STATE OF NORTH CAROLINA
DEPARTMENT OF TRANSPORTATION

May 8, 2013

Subject: **Response to On Hold Letter** for request for Section 401 Water Quality Certification Modification, Wilmington Bypass from north of US 74/76 in Brunswick County to US 421 in New Hanover County. DWQ Project No. 10-0867v.4. TIP R-2633B.

Reference: NCDOT Modification Request, dated April 3, 2013
NCDWQ On Hold Letter, dated April 19, 2013, received April 26, 2013

PERMIT DRAWING
SHEET 20g OF 73
REVISED: 1/20 /2015

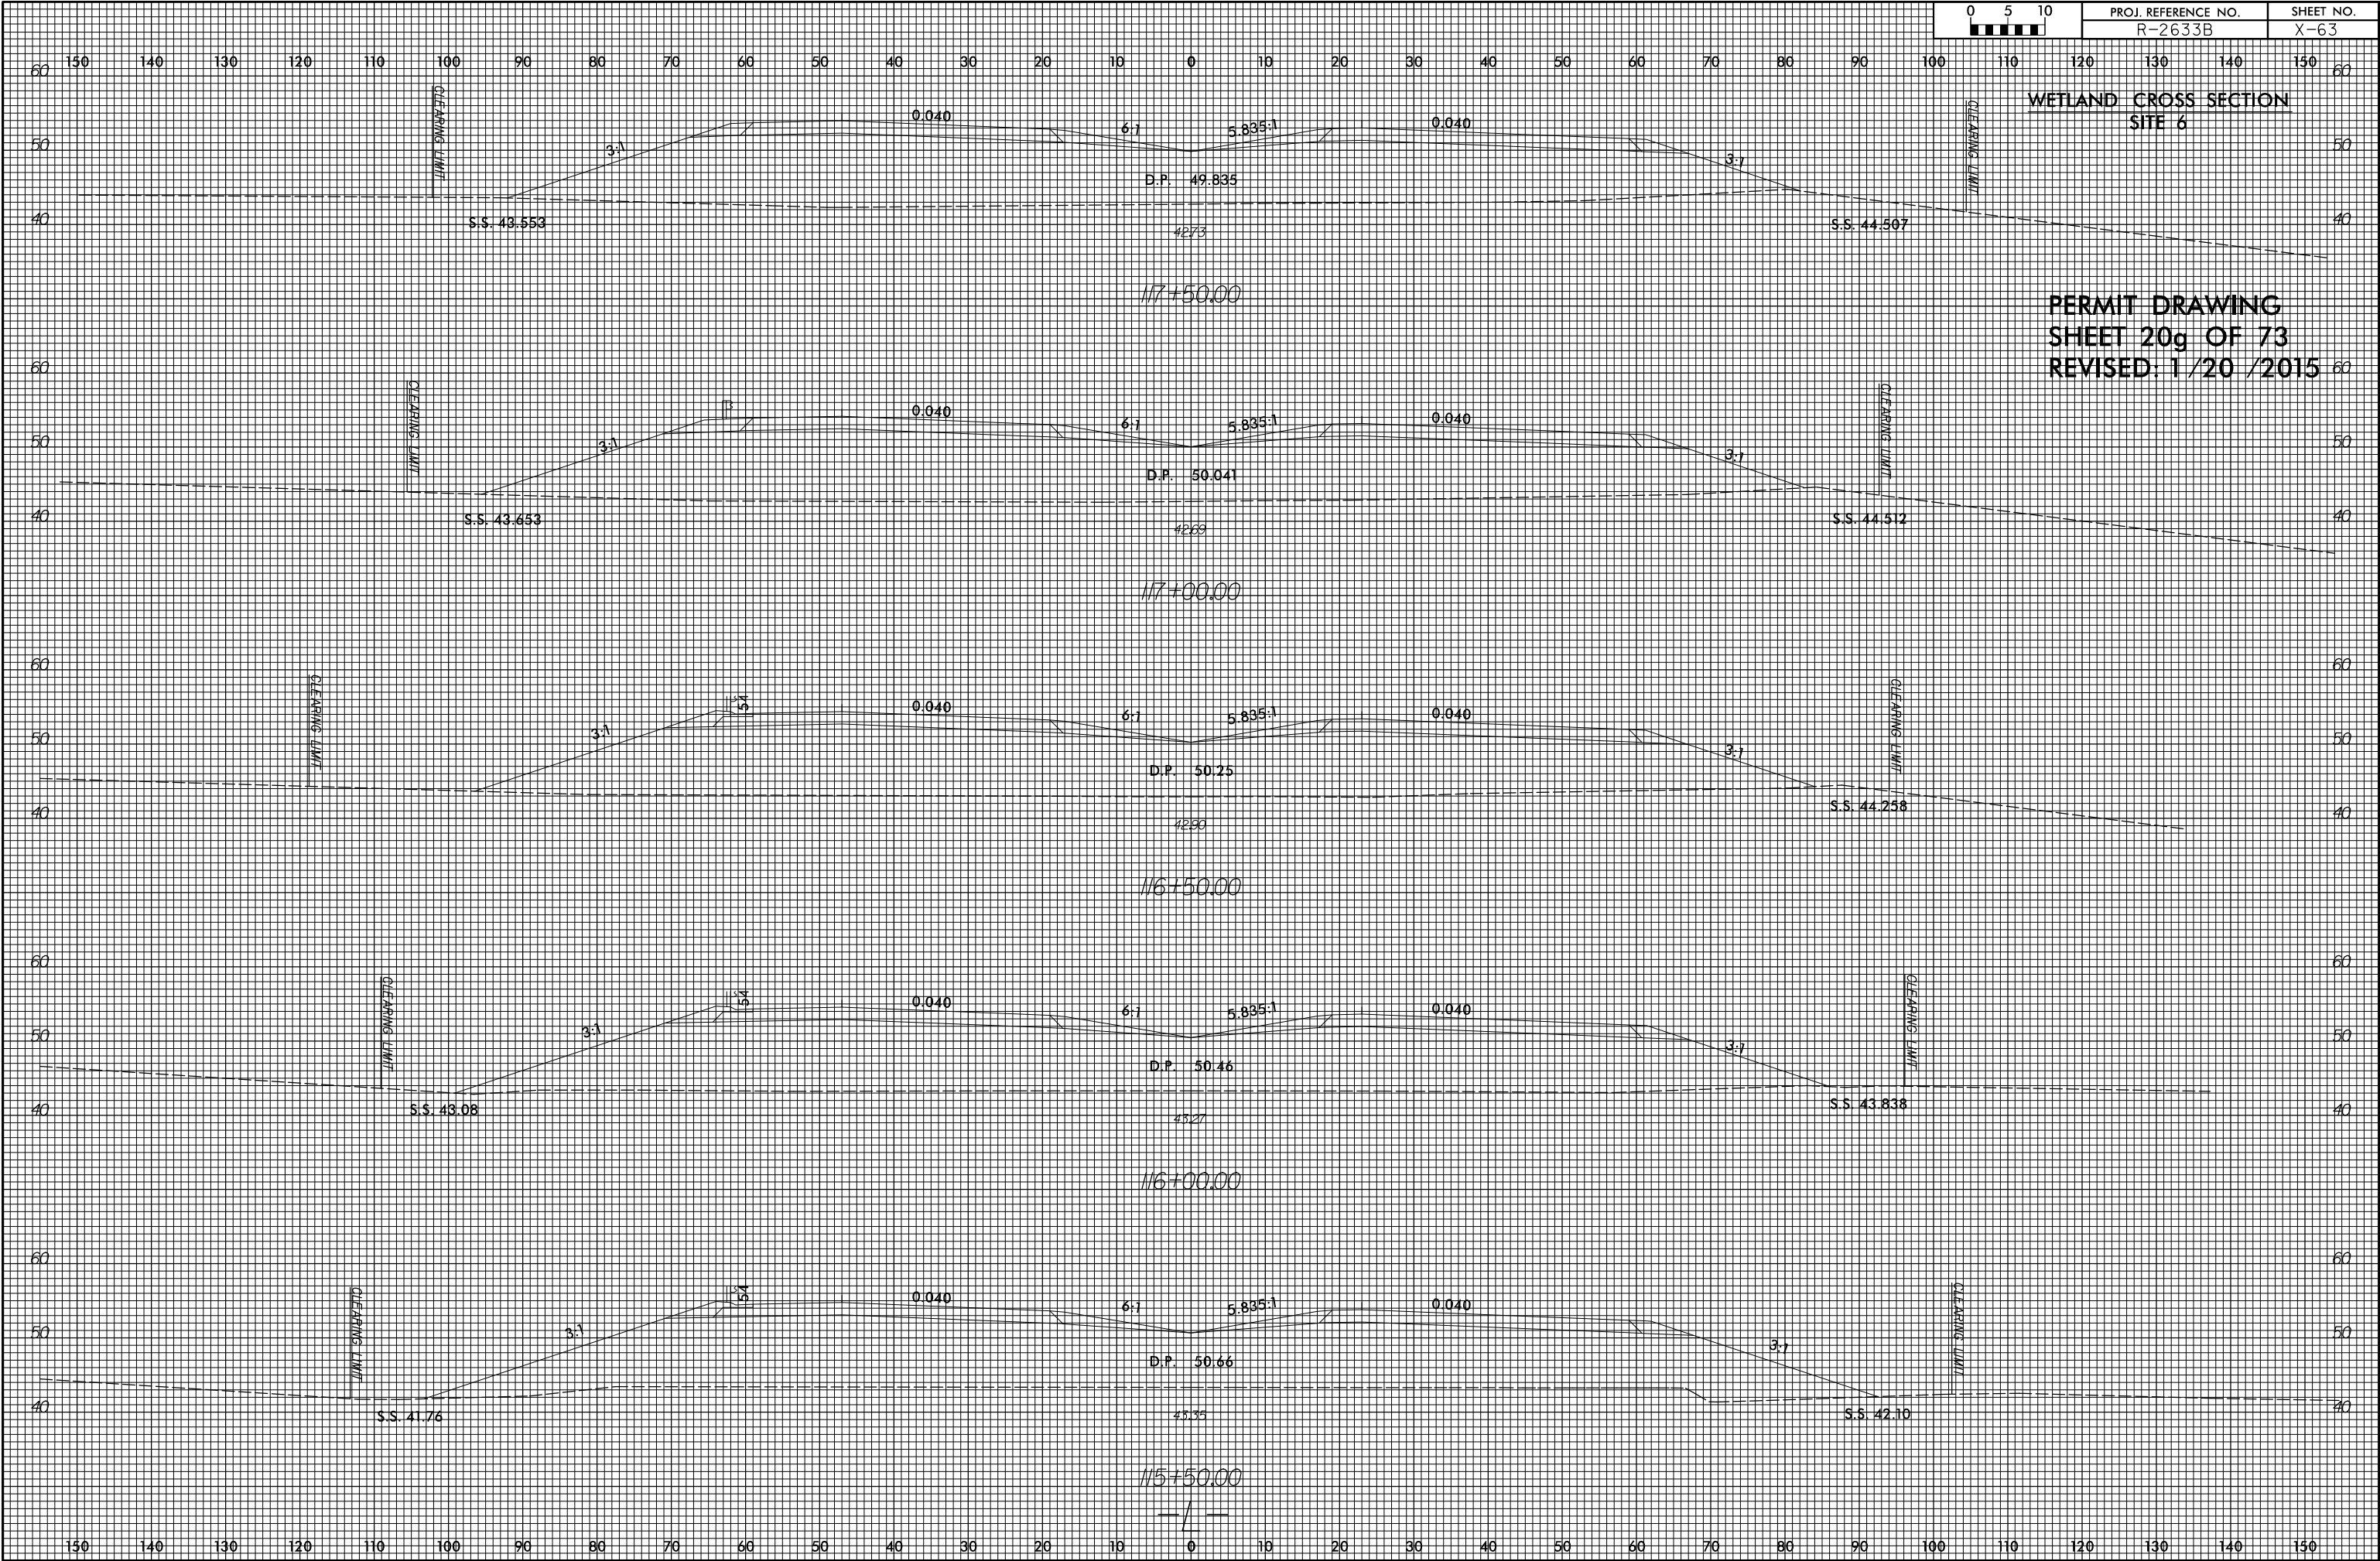
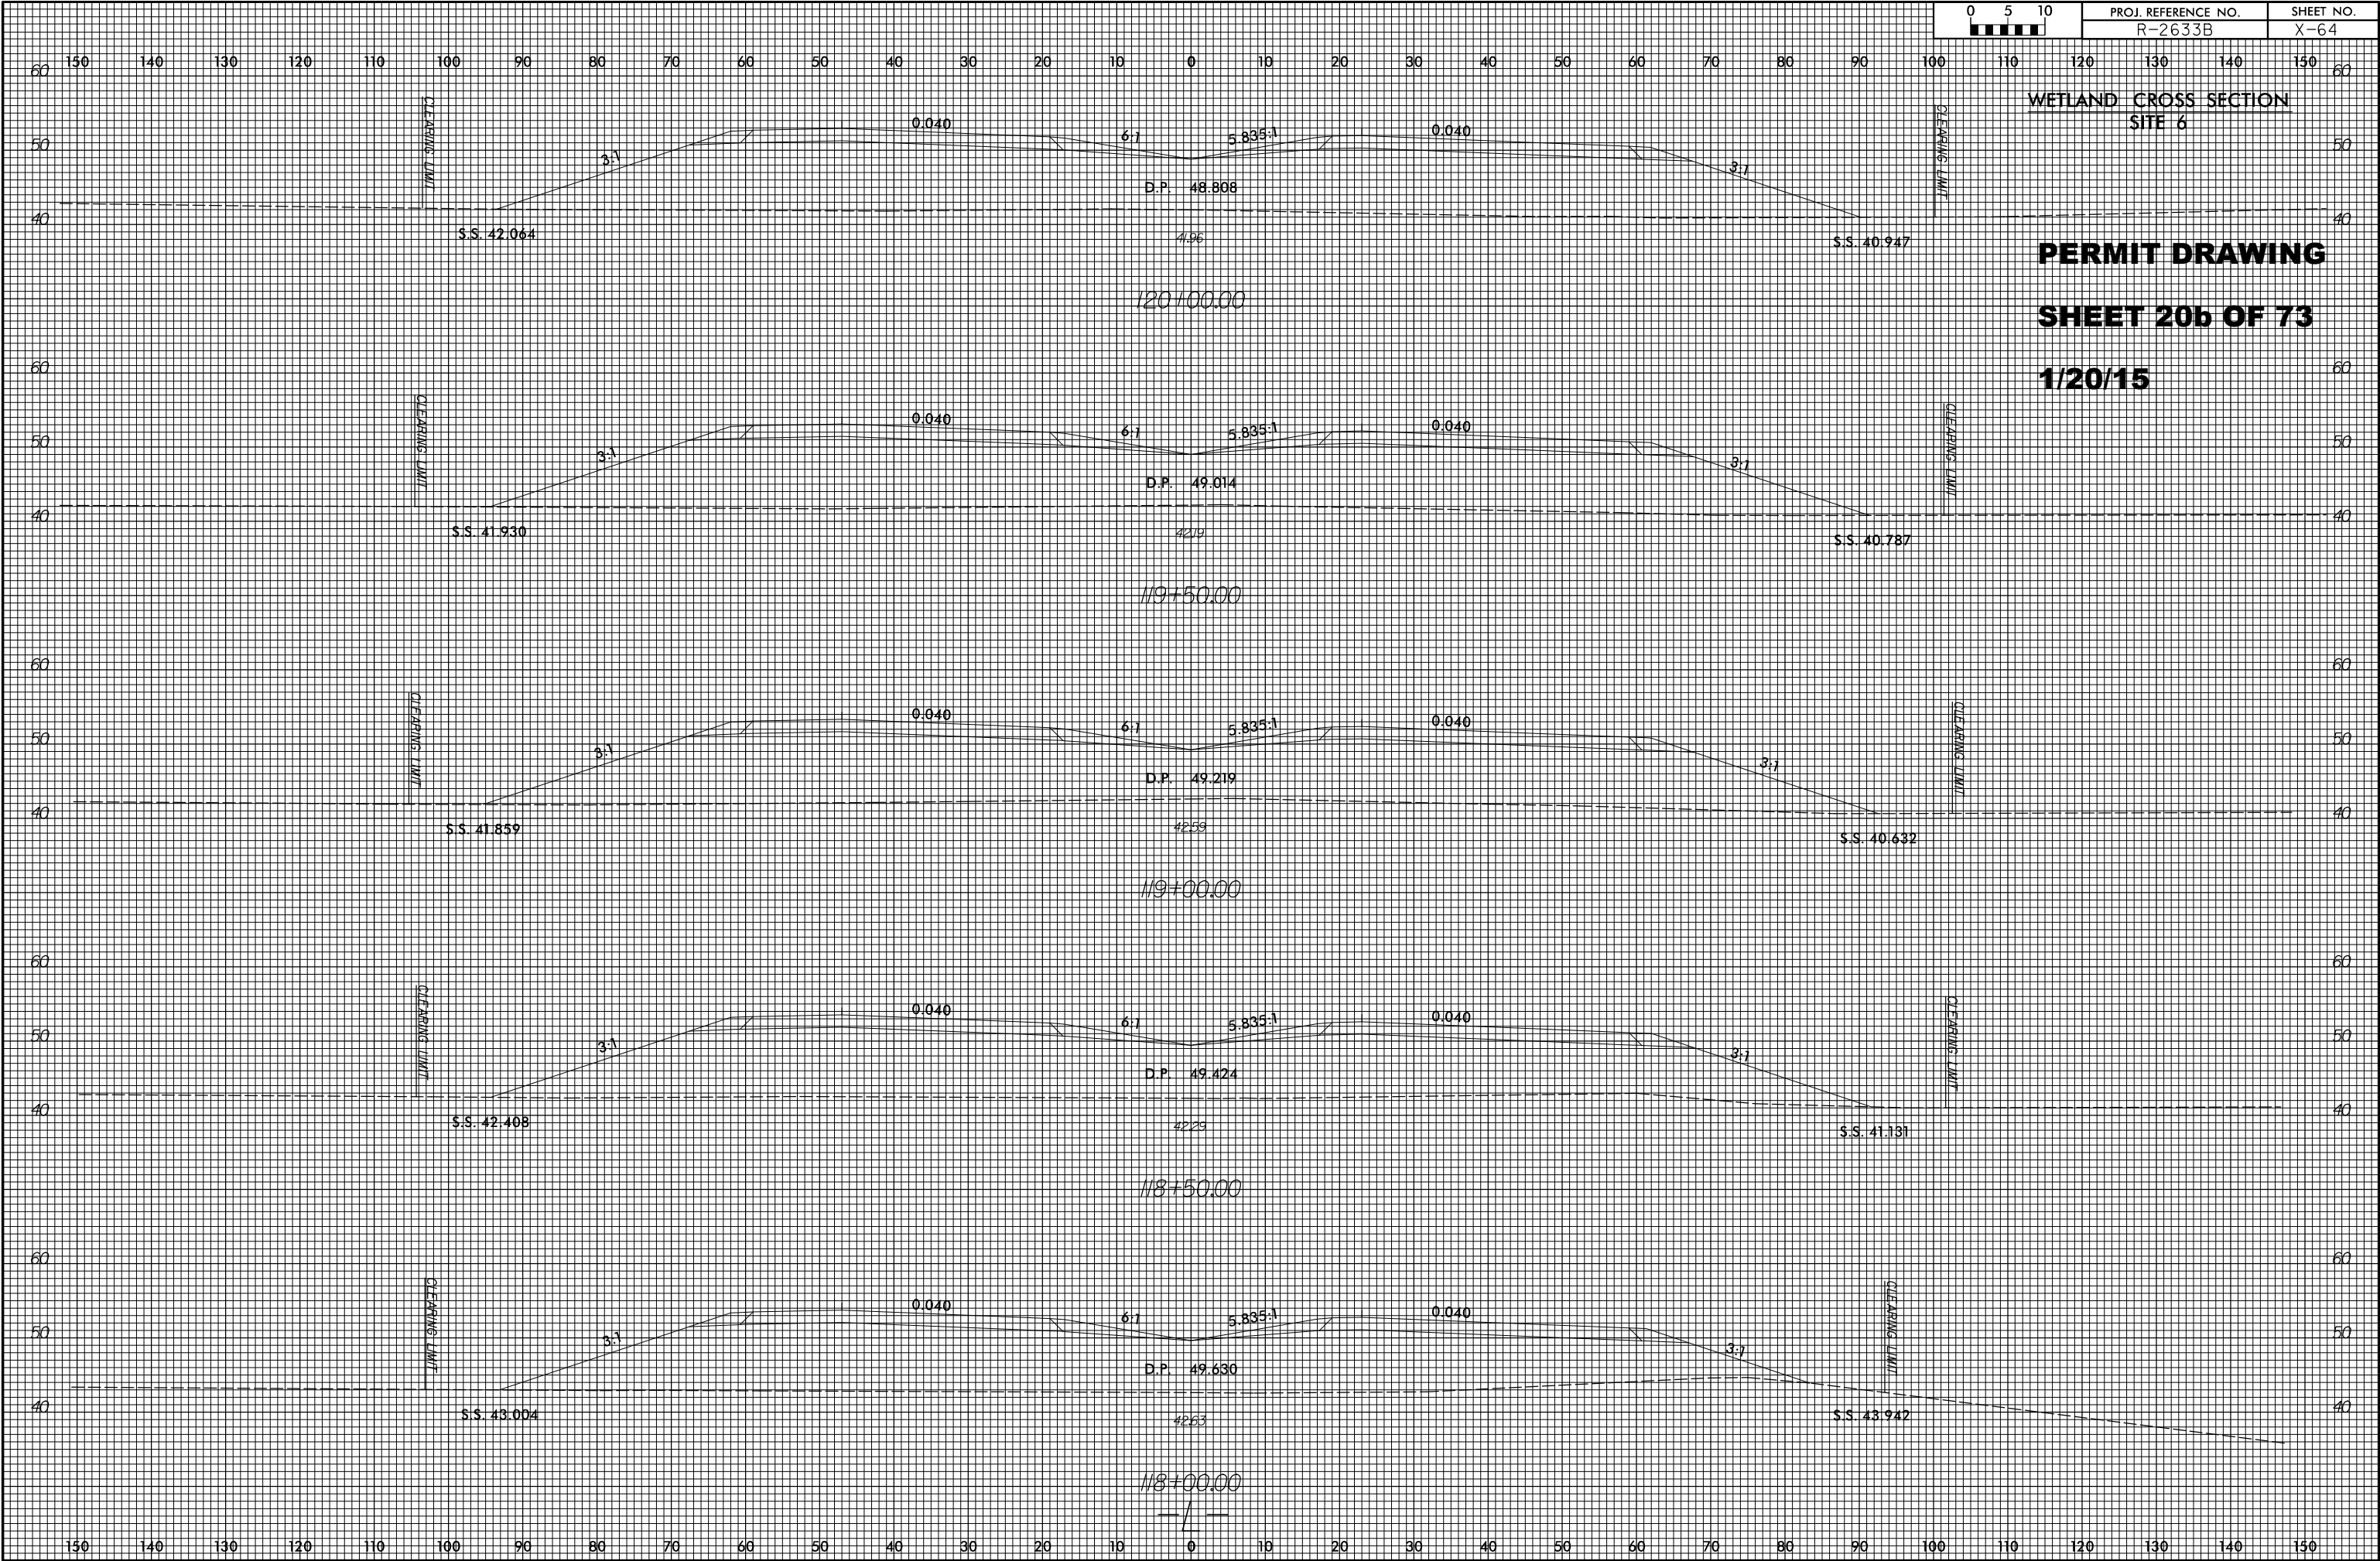
2. Site 6 – no cross sections were provided for the wetland impacts between Sta. 109+28 to 118+00 and 123+00 to 135+00. Please provide these cross sections.

3. Your application states in the "Avoidance and Minimization" section that 3:1 slopes will be used in wetland areas to minimize wetland impacts. Upon review of the application there are several cross sections that show greater than 3:1 slopes. Please correct.

Representative cross sections were provided in the application. Nevertheless, additional cross sections are enclosed, providing a larger sampling of cross sections in jurisdictional areas.

Sites 3, 5 & 6 permit drawings, cross sections, and impact summary sheet have been revised and are enclosed. As a result, proposed permanent fill has decreased at these sites by 1.42 acres. Additionally, we will submit a revised request to EEP for an updated acceptance letter.
